TOWN AND COUNTRY PLANNING ACT 1990 FULL

Reference:	H16-0410-23	Date of Decision:	14th June 2023
Applicant:	Mrs F T Mir Javadi 13a Fishpond Lane Holbeach Spalding PE12 7DE		
Location:	106 Halmer Gate Spalding		
Description:	Change of use of residential dwelling to HMO - re-submission of H16-1111-22

HMO AT 106 VALMER GATE
SPALDING FOR
MRS F T MR JAVADI

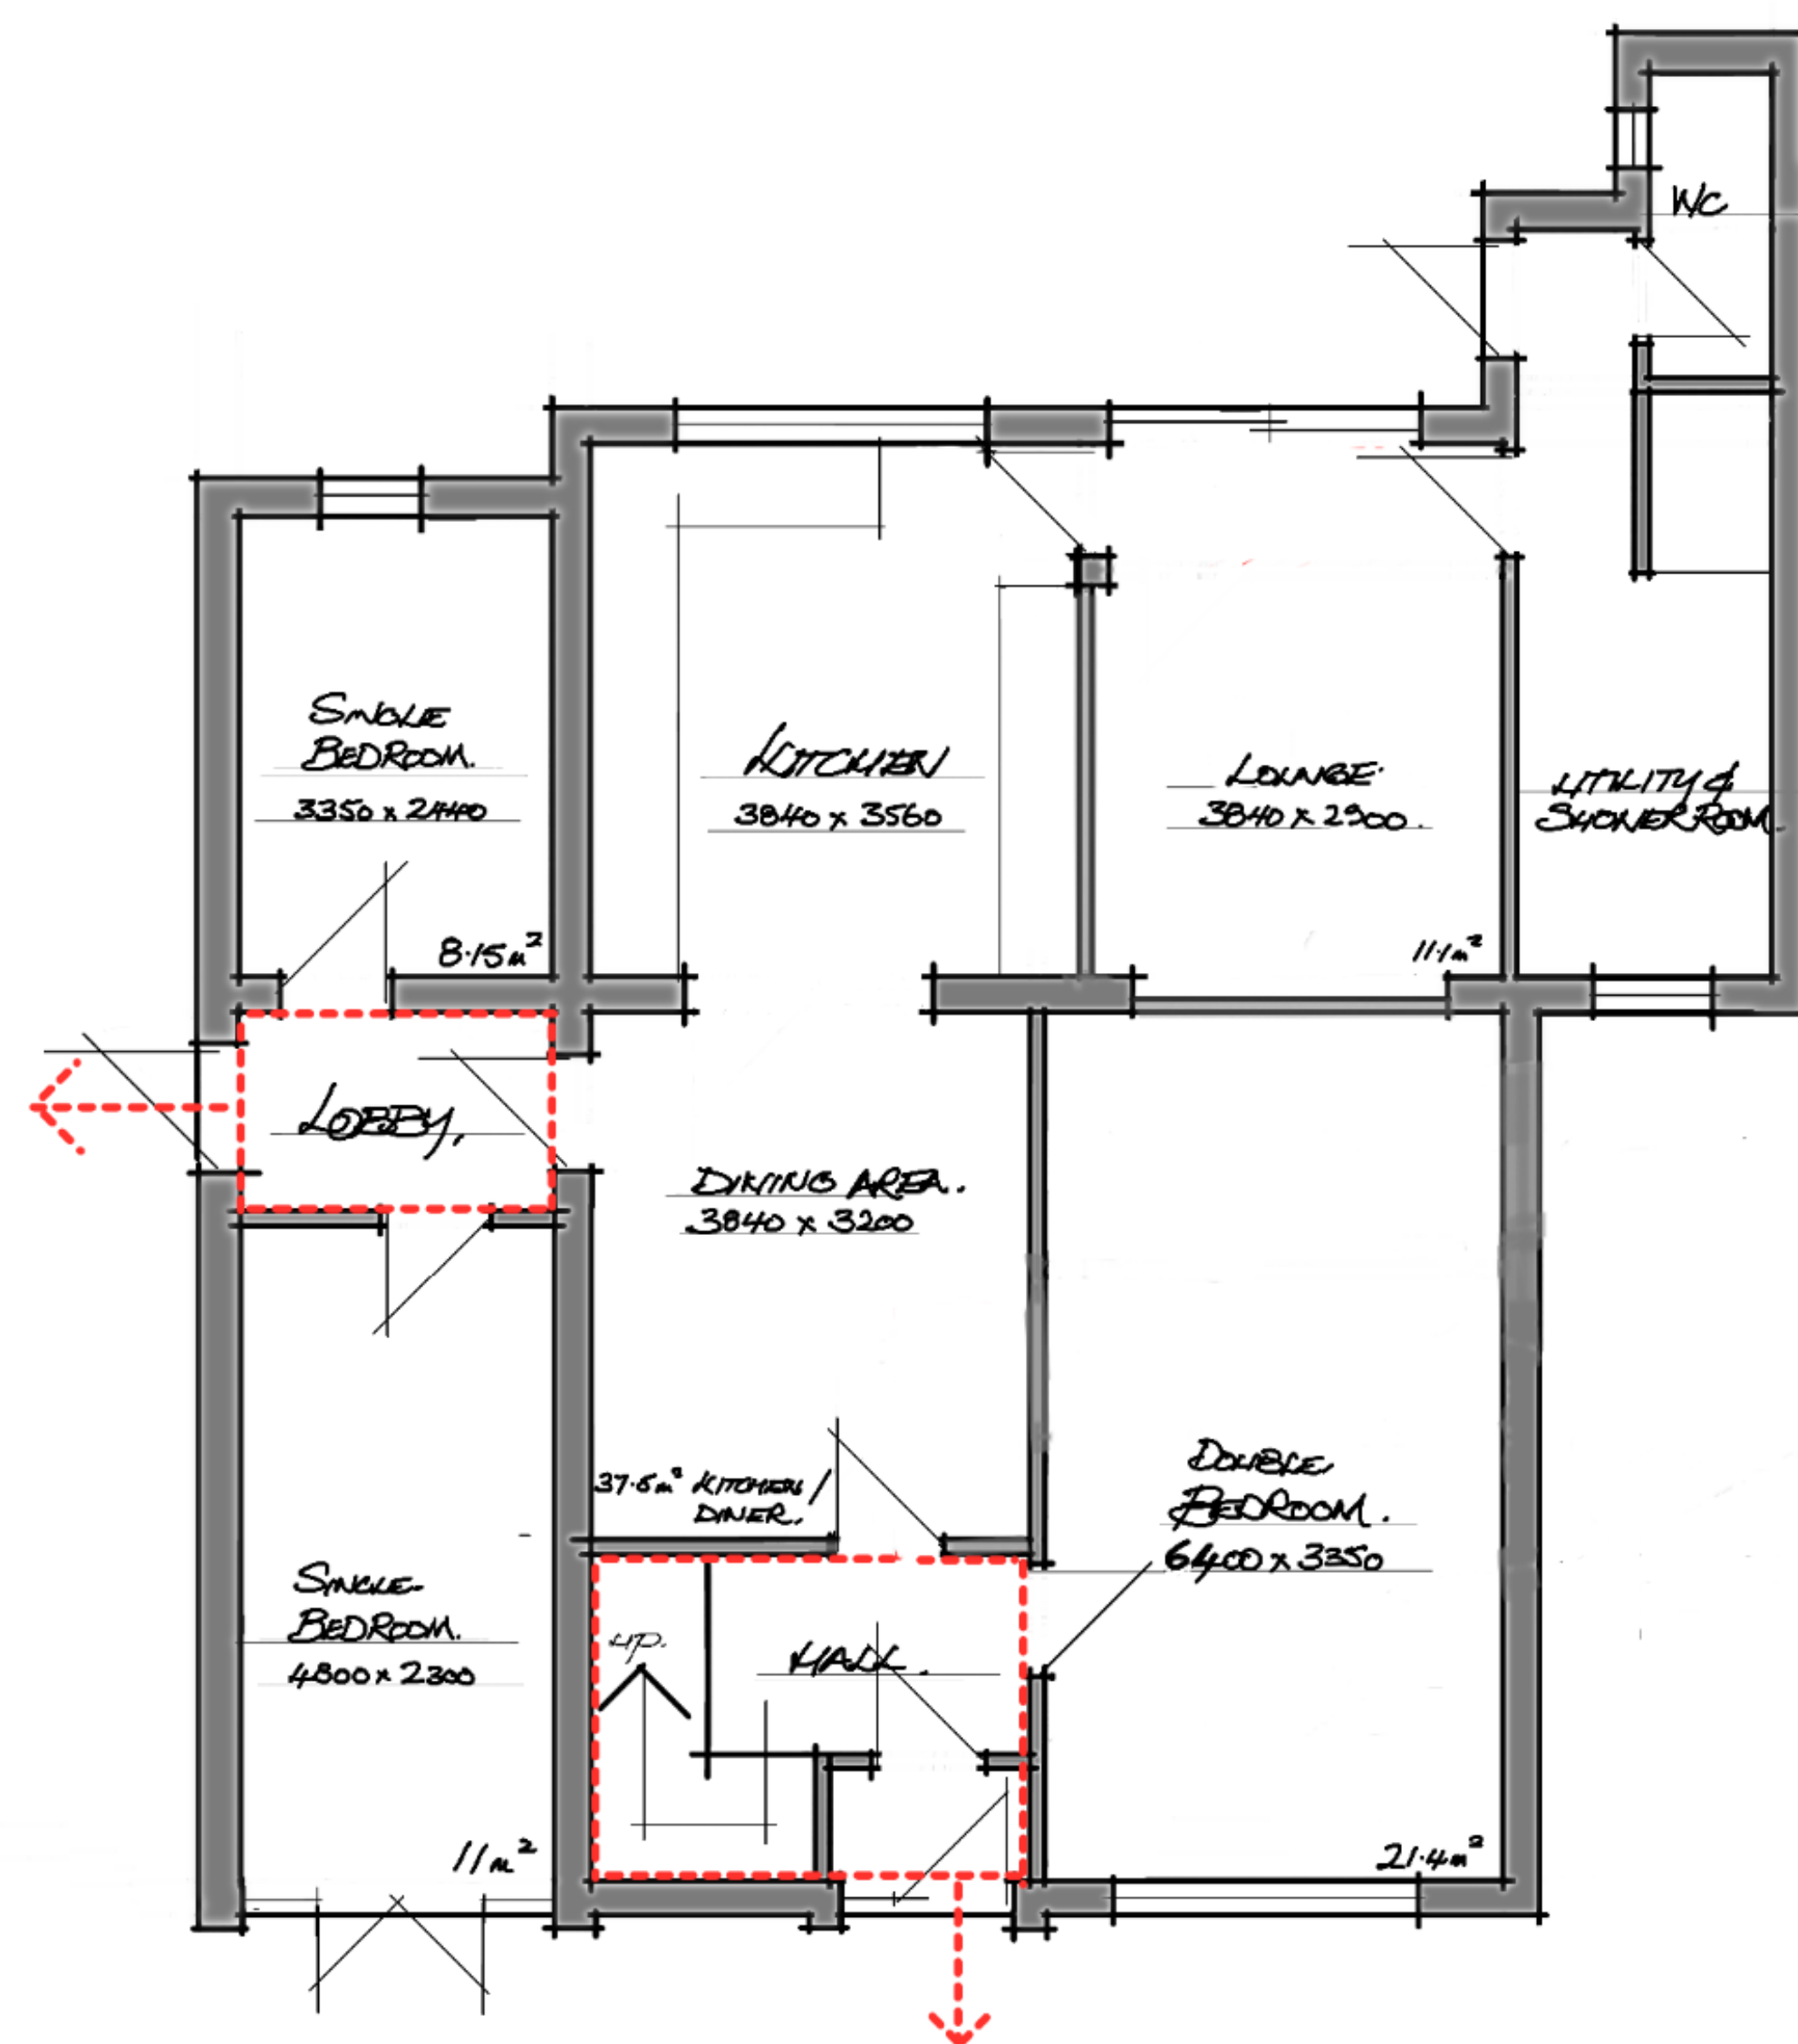
- 1 The property is considered to be of an inadequate size to accommodate what would likely be between seven and nine people by virtue of small bedroom sizes and inadequate amenity space. This insufficient amenity space would detrimentally impact the standard of living of potential occupiers. This directly contradicts criteria 7 of Policy 21 of the South East Lincolnshire Local Plan which requires sufficient amenity space for HMOs.

- 2 A single shared communal living room would be insufficient to meet the needs of at least seven residents, forcing residents to spend excessive time either within their own rooms or within the communal garden space. This increase in outdoor gathering would increase the levels of noise pollution to the detriment of neighbouring occupants. This explicitly contradicts criteria 2 of Policy 21 and Policy 2 and 3 of the South East Lincolnshire Local Plan which ensures that neighbouring amenity is not impeded by development.

- 3 Given that the HMO is intended to accommodate a minimum of seven persons, there is the potential for a large number of vehicles to be associated with the property. The application has stated that five parking spaces will be provided; however, two of these spaces would result in vehicles being obstructed and unable to manoeuvre. It is considered that this is insufficient parking space given the potential number of residents, and that as a result the proposal may lead to the indiscriminate parking of vehicles on Halmer Gate and would impede traffic flow along a road that is particularly busy. The lack of room for turning may result in vehicles exiting the property in reverse, potentially damaging the safety of road users.
